Macquarie Park Data Centre (SSD-10467) - Notice of Exhibition

Thank you for your correspondence via the Major Projects Portal on 19 November 2020, requesting Transport for NSW (TfNSW) to review and comment on the above.

Swept path analysis

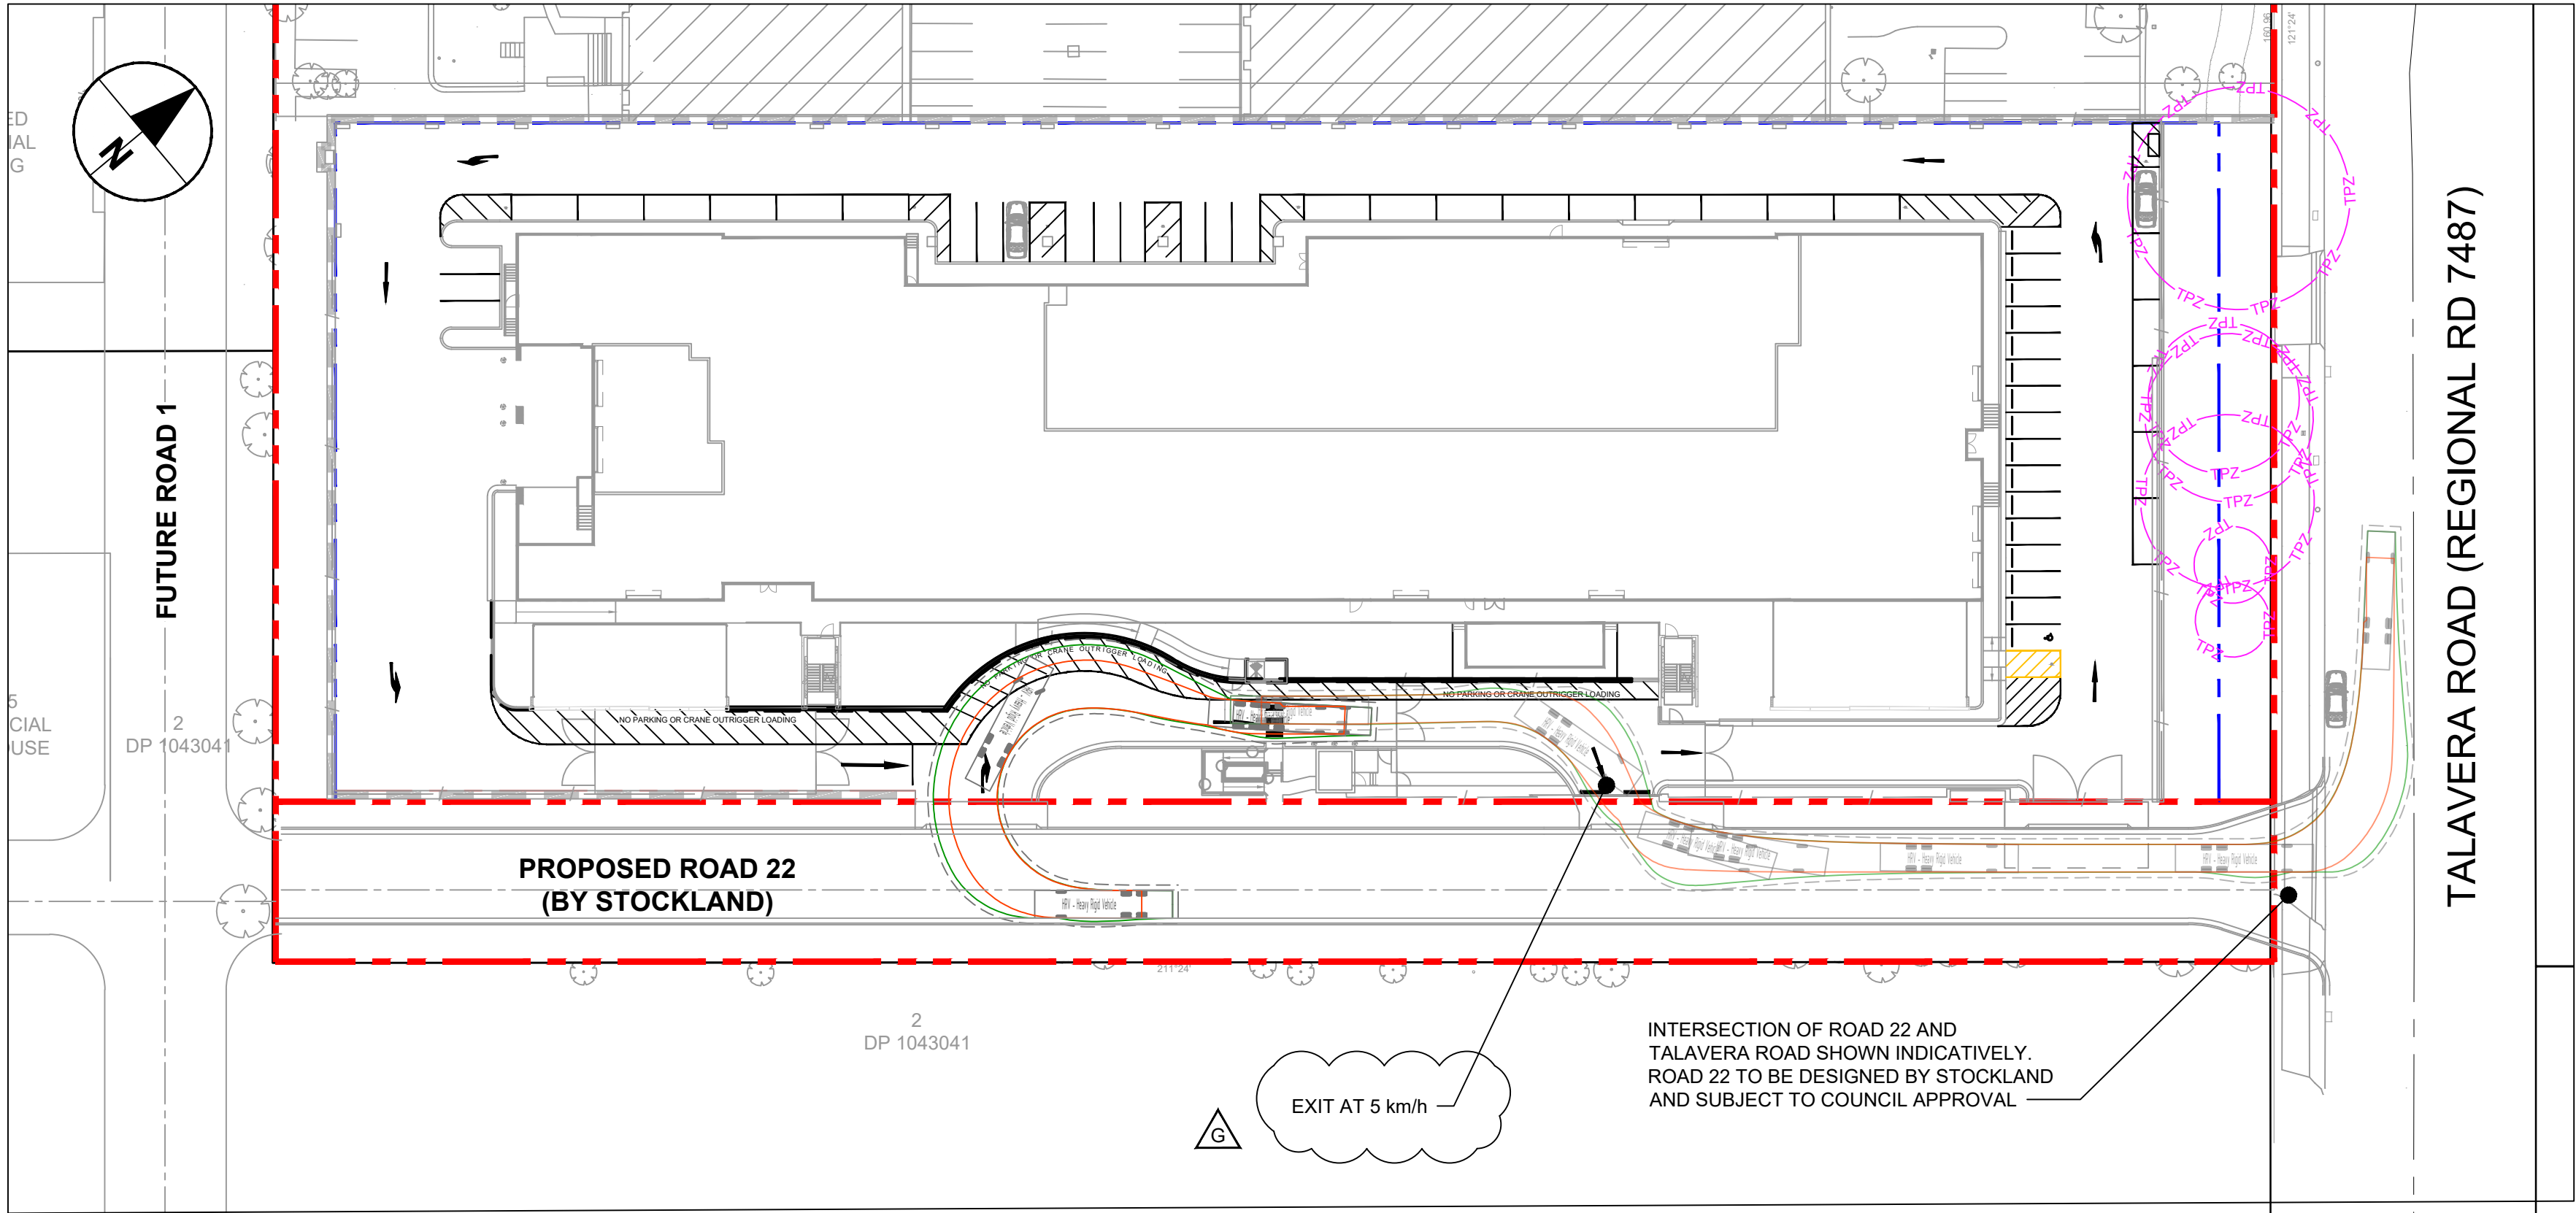
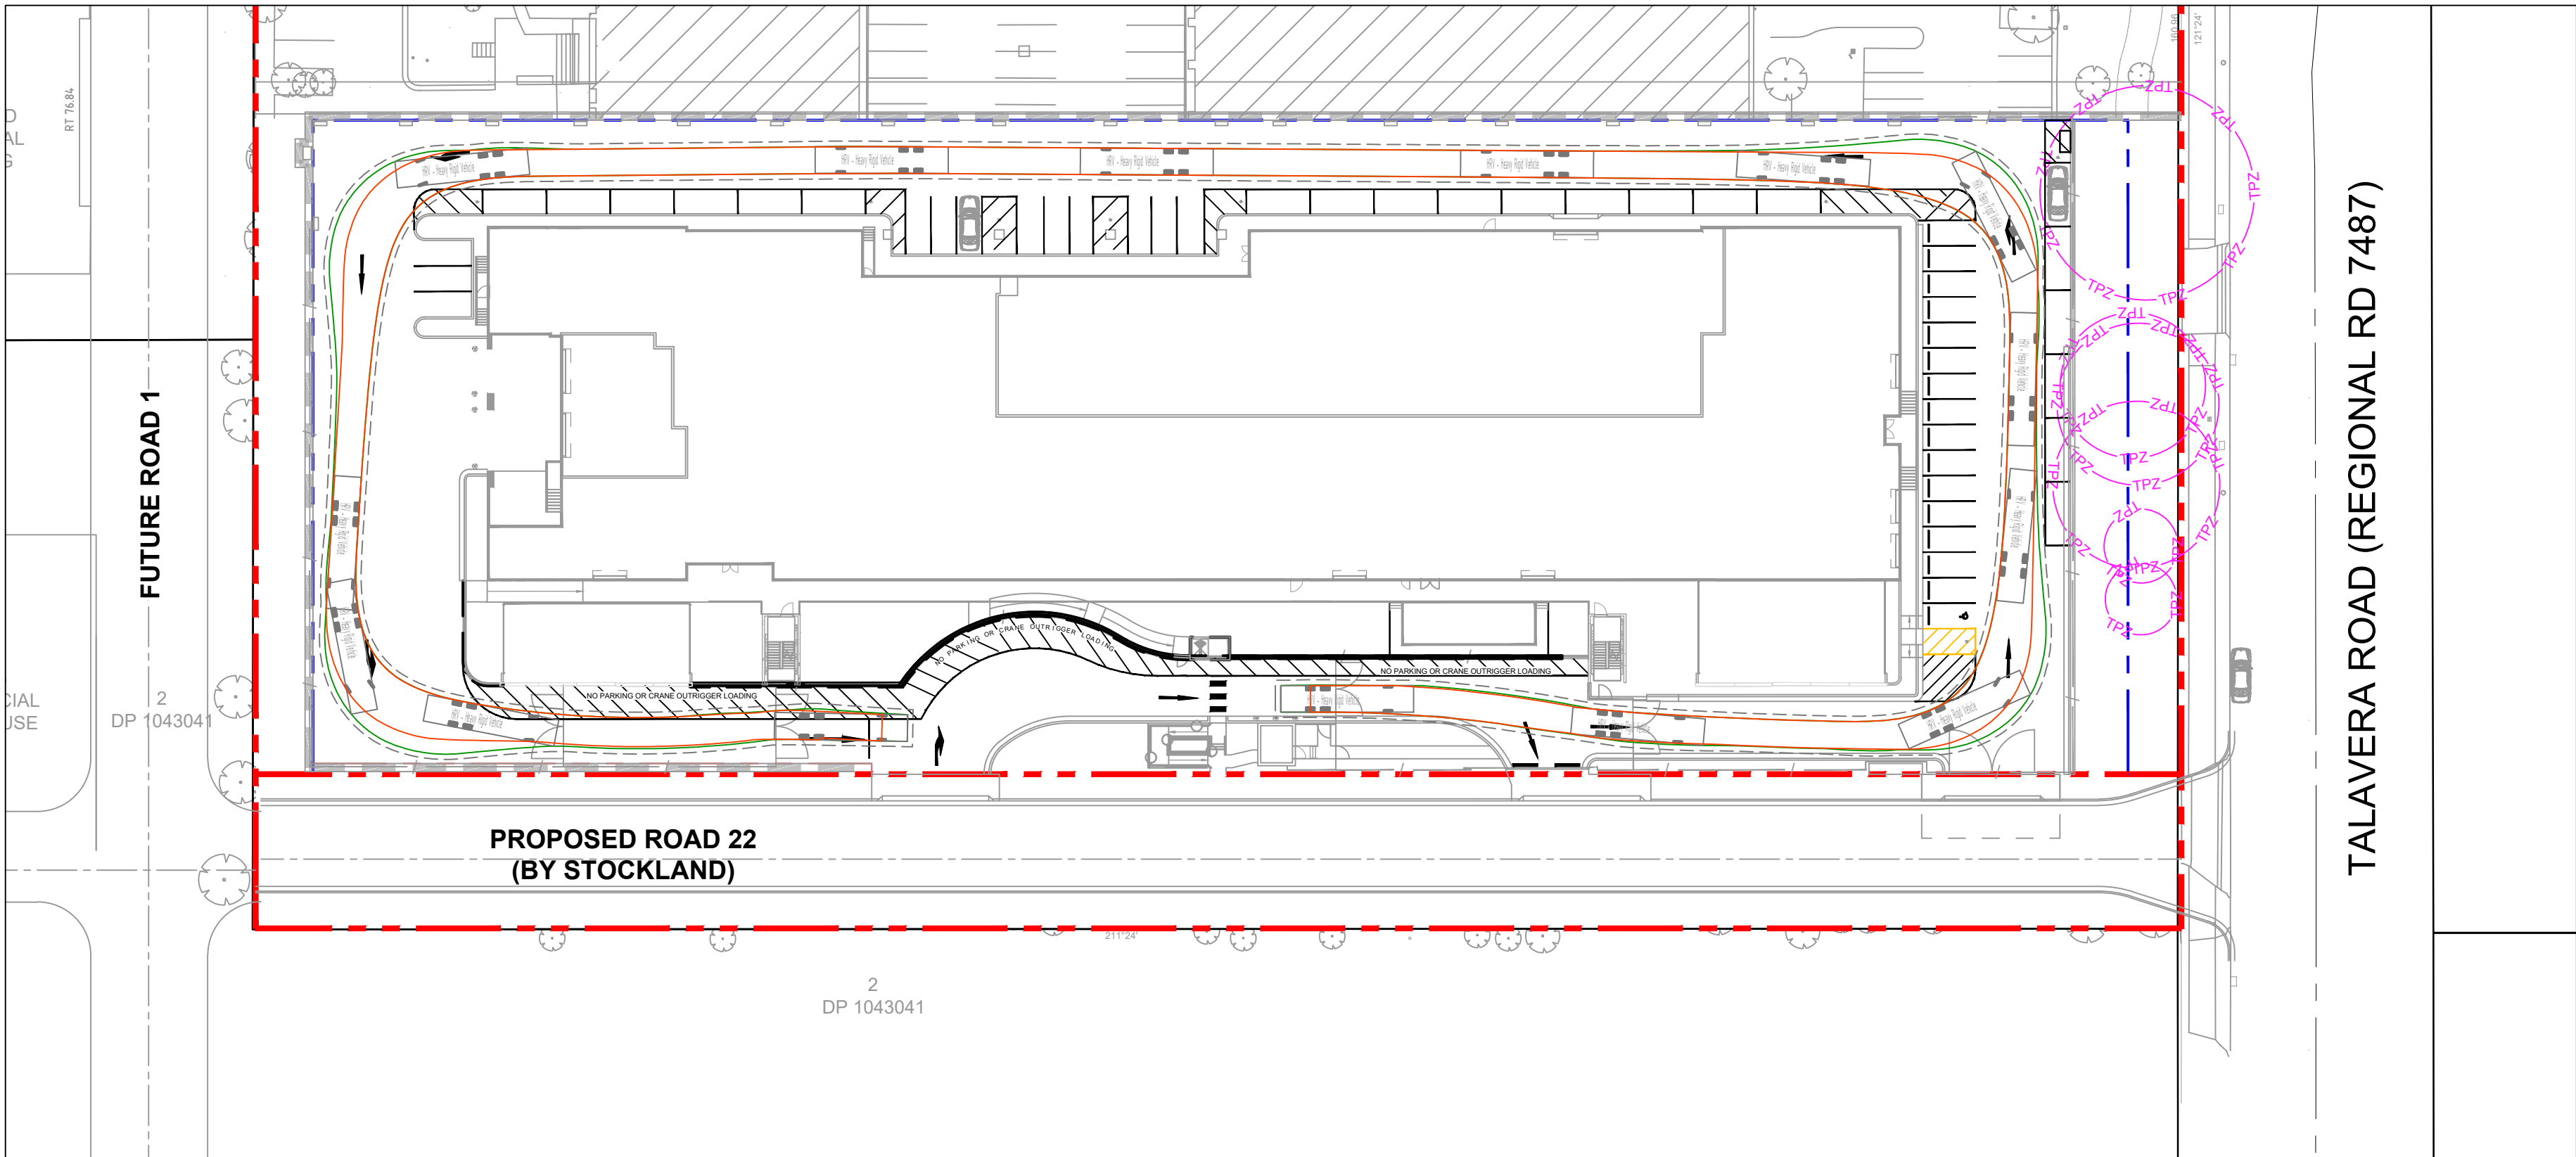
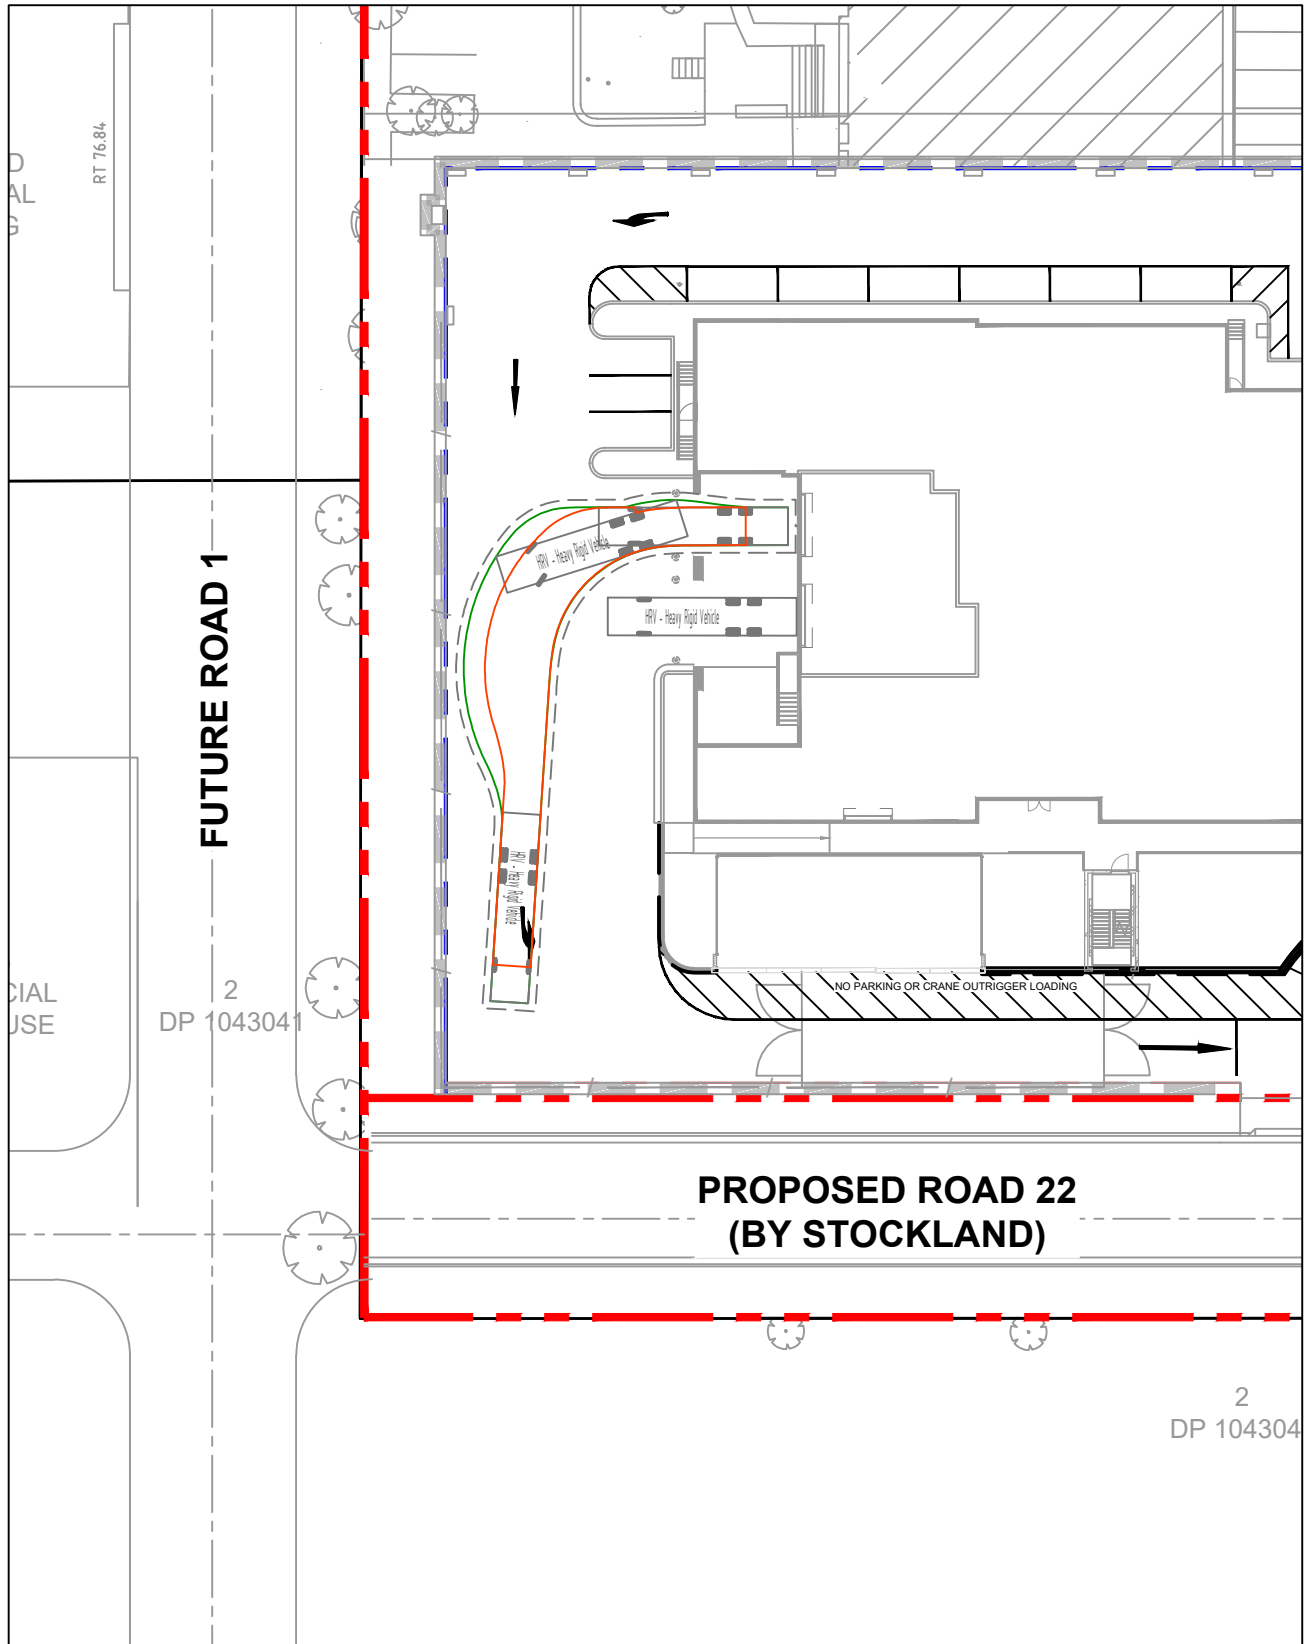
Based on the swept path analysis report prepared to support the development application, several potential conflict points are noticed between service vehicles accessing the site and the vehicles travelling opposite direction as well as pedestrian / cyclists along Road 22 and at the intersections of Talavera Road / Road 22 and Road 22 / accesses to the site. This would have the potential to cause road safety related incidents at these locations.

It is requested that the applicant procures and independent Stage 2 (Concept Plan) Road Safety Audit as part of the applicant's Response to Submissions. This should include the service vehicles access to the site along Road 22 and at the intersections of Talavera Road / Road 22 and Road 22 / accesses to the site. The audit should be in accordance with *Austroads Guide to Road Safety Part 6: Managing Road Safety Audits* and *Austroads Guide to Road Safety Part 6A: Implementing Road Safety Audits* by an independent TfNSW accredited road safety auditor.

Based on the results of the road safety audit, the applicant should review the design drawings and implement safety measures in consultation with TfNSW as required.
